Date: 9 August 2018

Planning Act 2008 – Section 51

Application by Suffolk County Council for an Order Granting Development Consent for the Lake Lothing Third Crossing

Advice following issue of decision to accept the application for examination

DRAWING: **Control tower and plant room site plan**
PROJECT: Lake Lothing Third Crossing

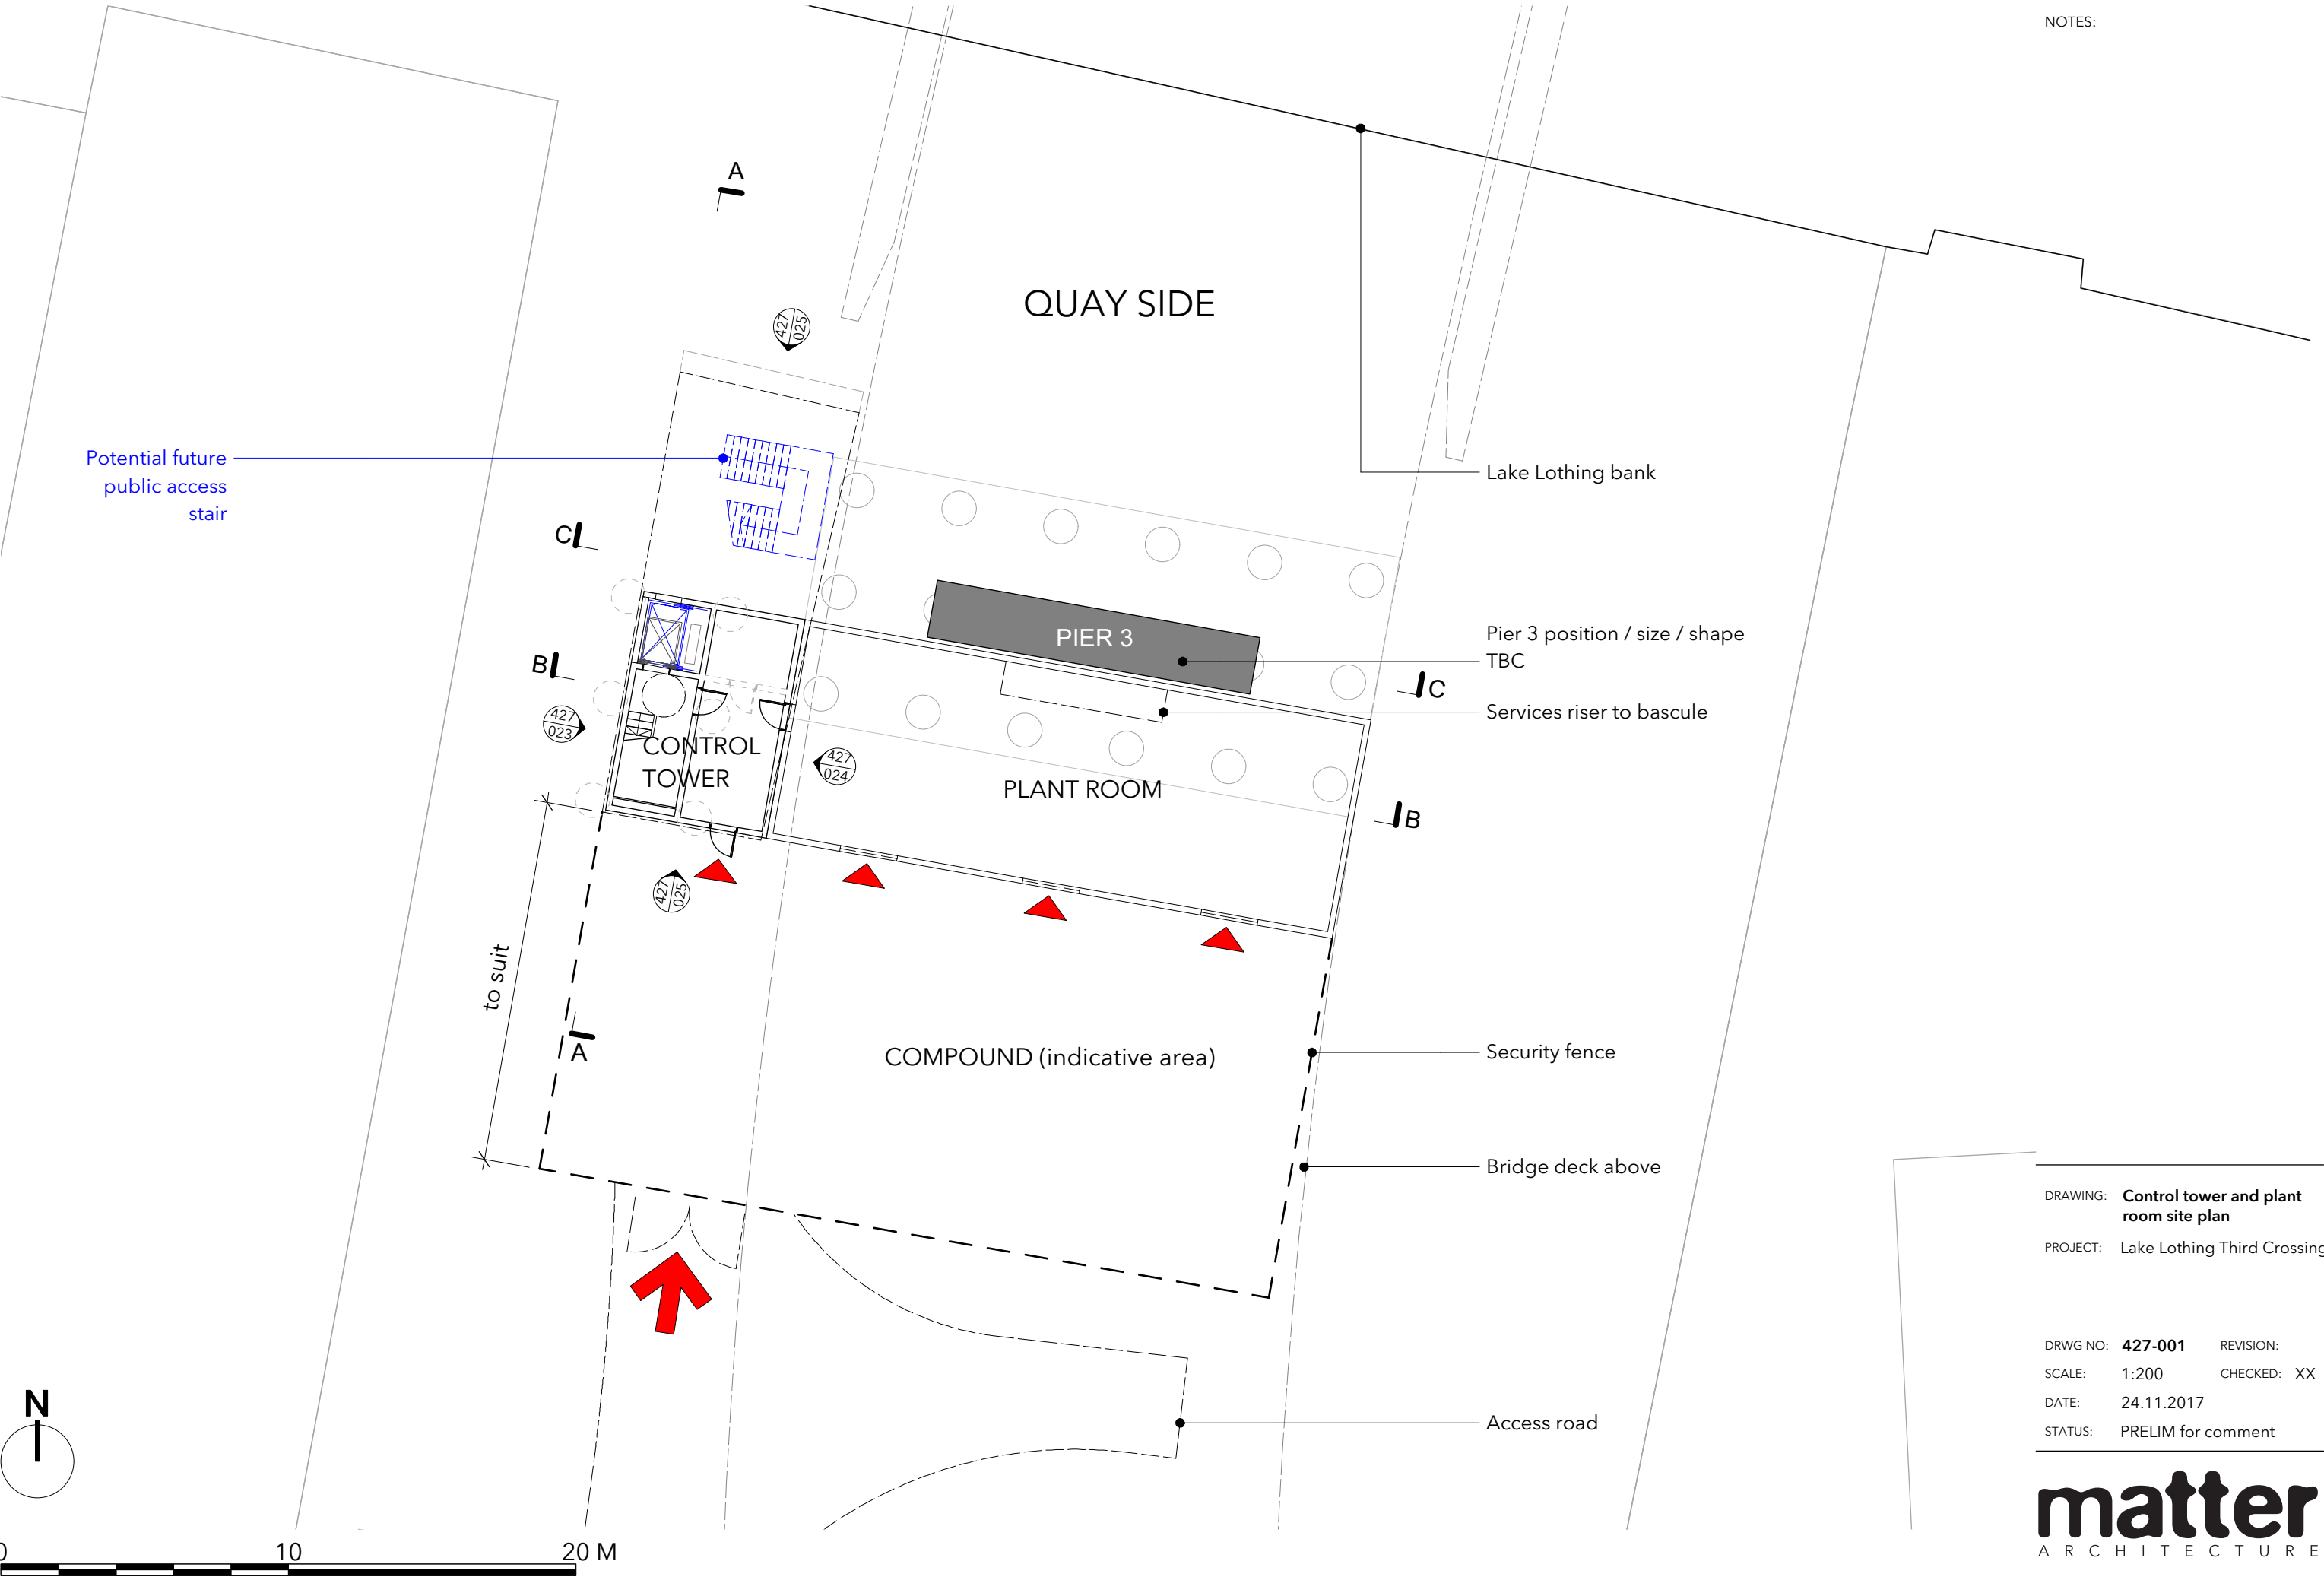
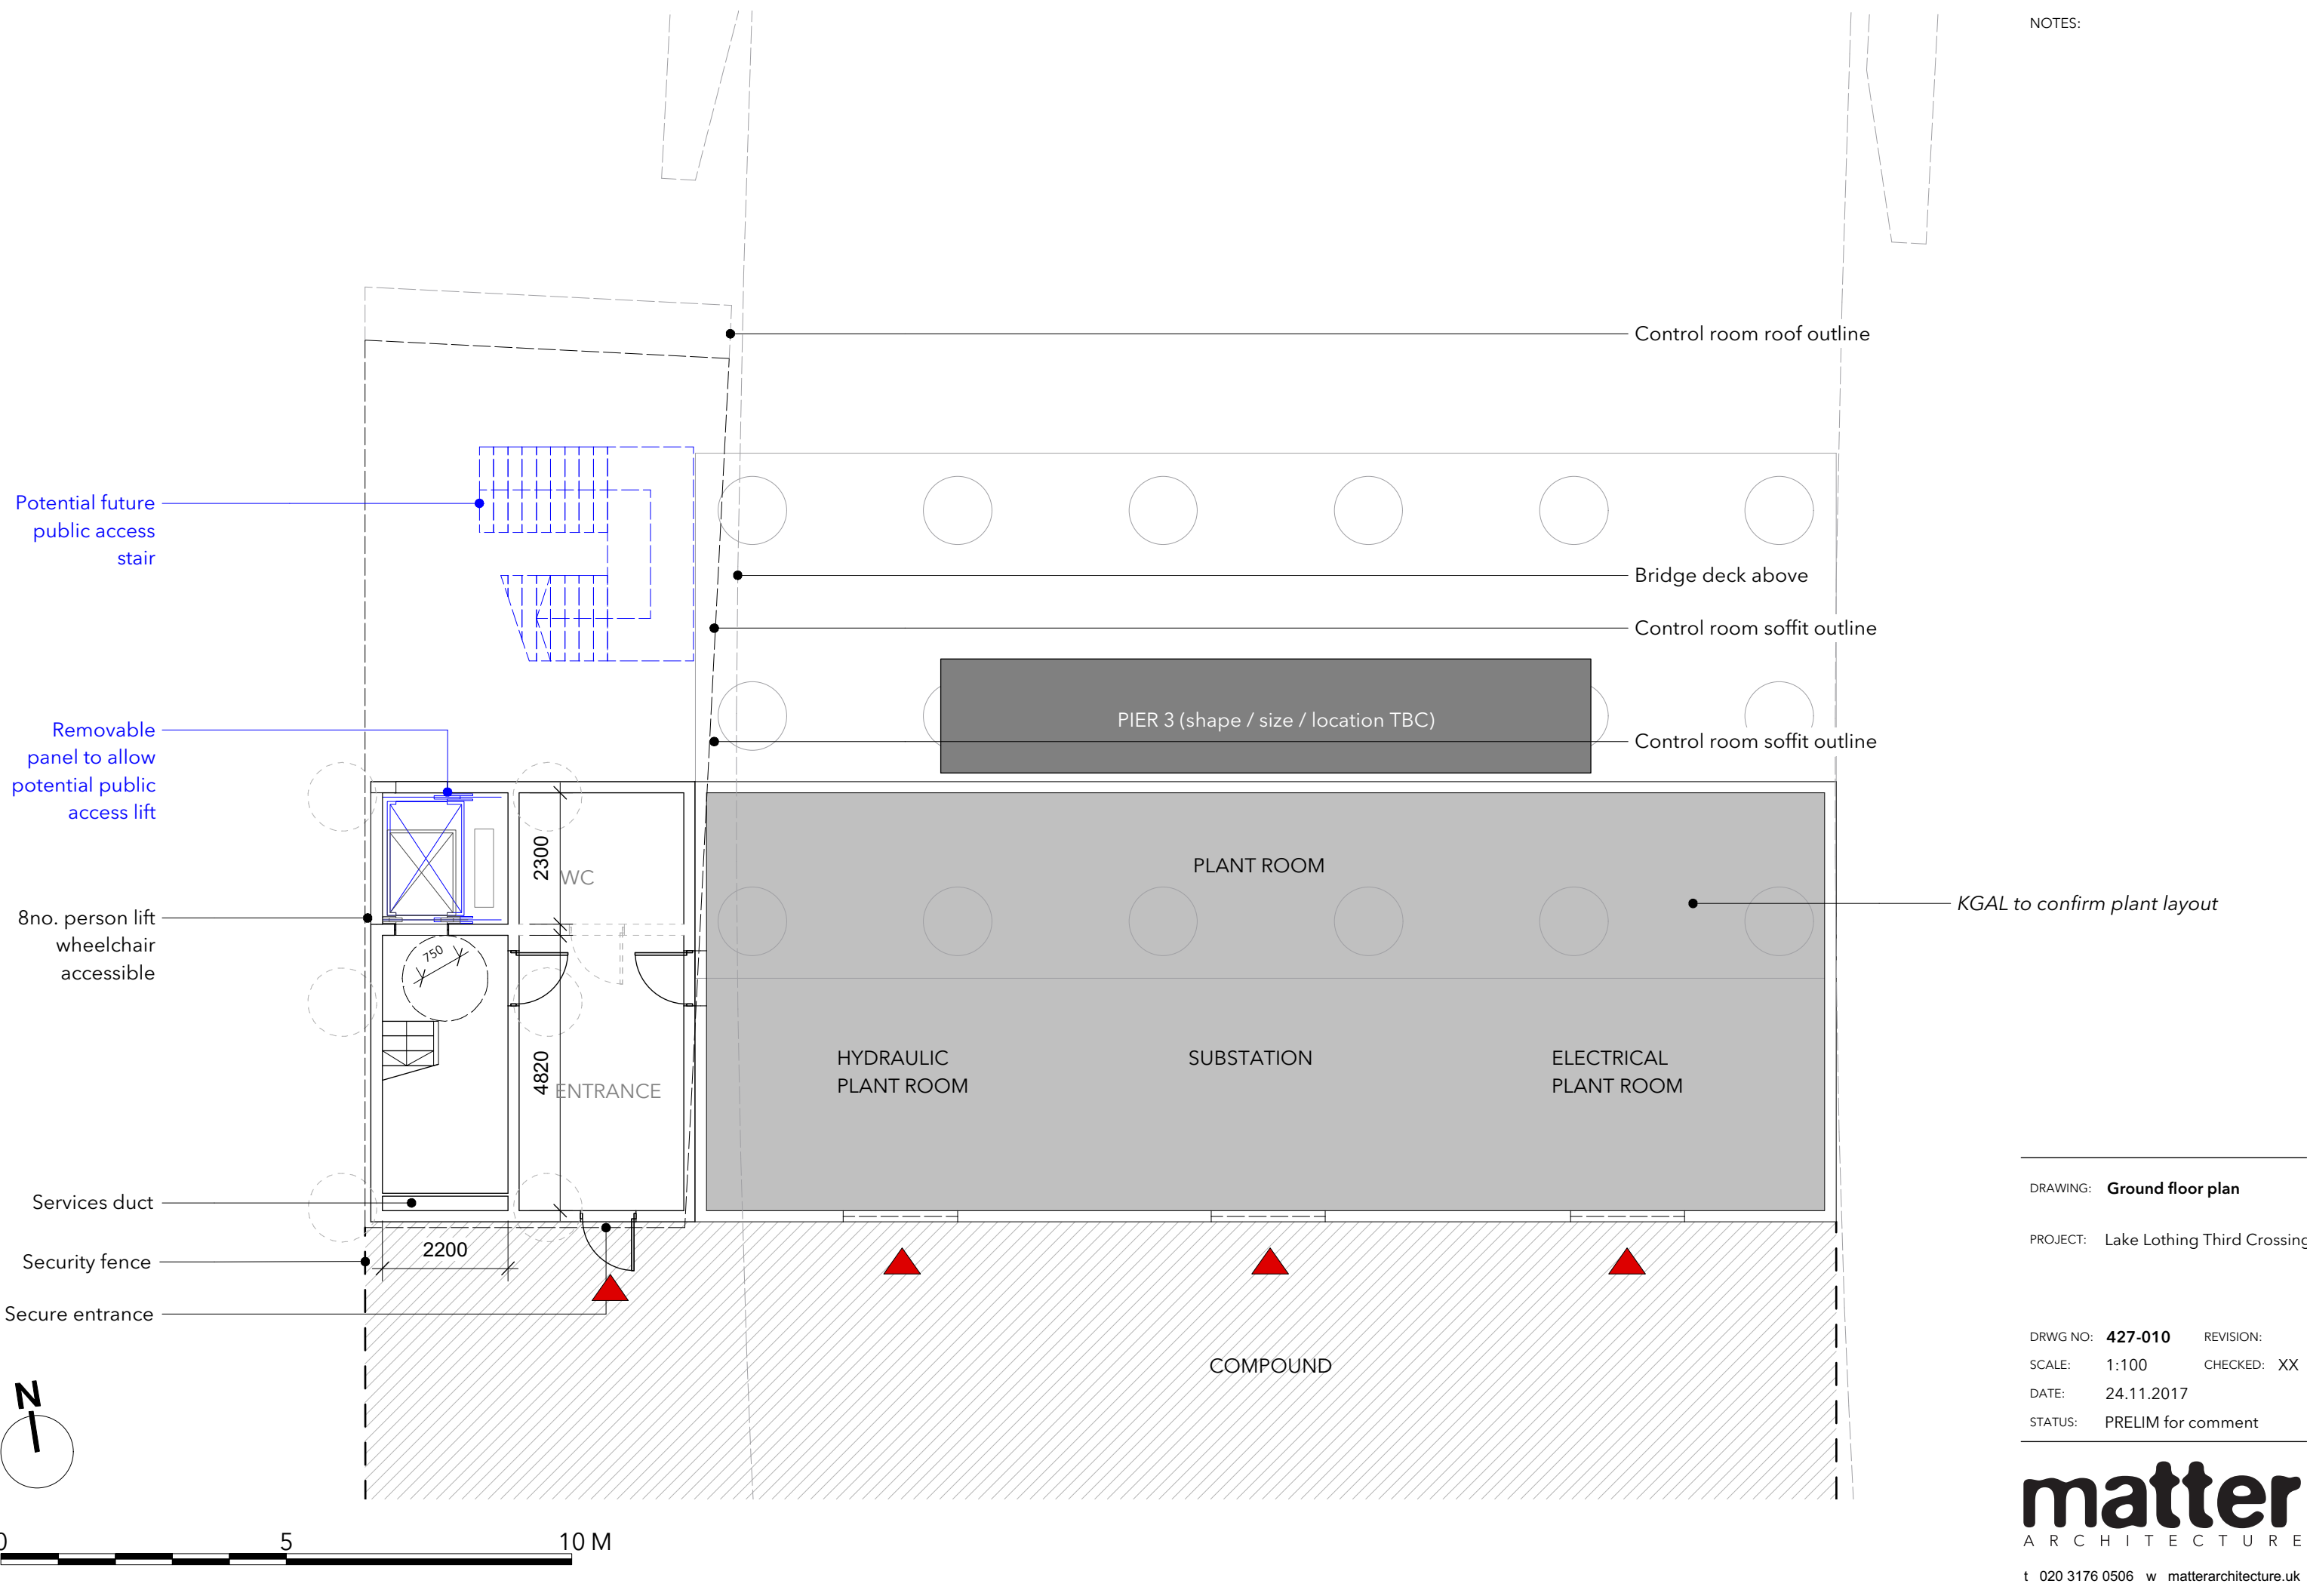
The Applicant is advised that the appointed ExA may request for the provision/ preparation of detailed technical plans and elevations for the design of the bridge, the bridge abutments and the control tower to inform the examination of design matters.
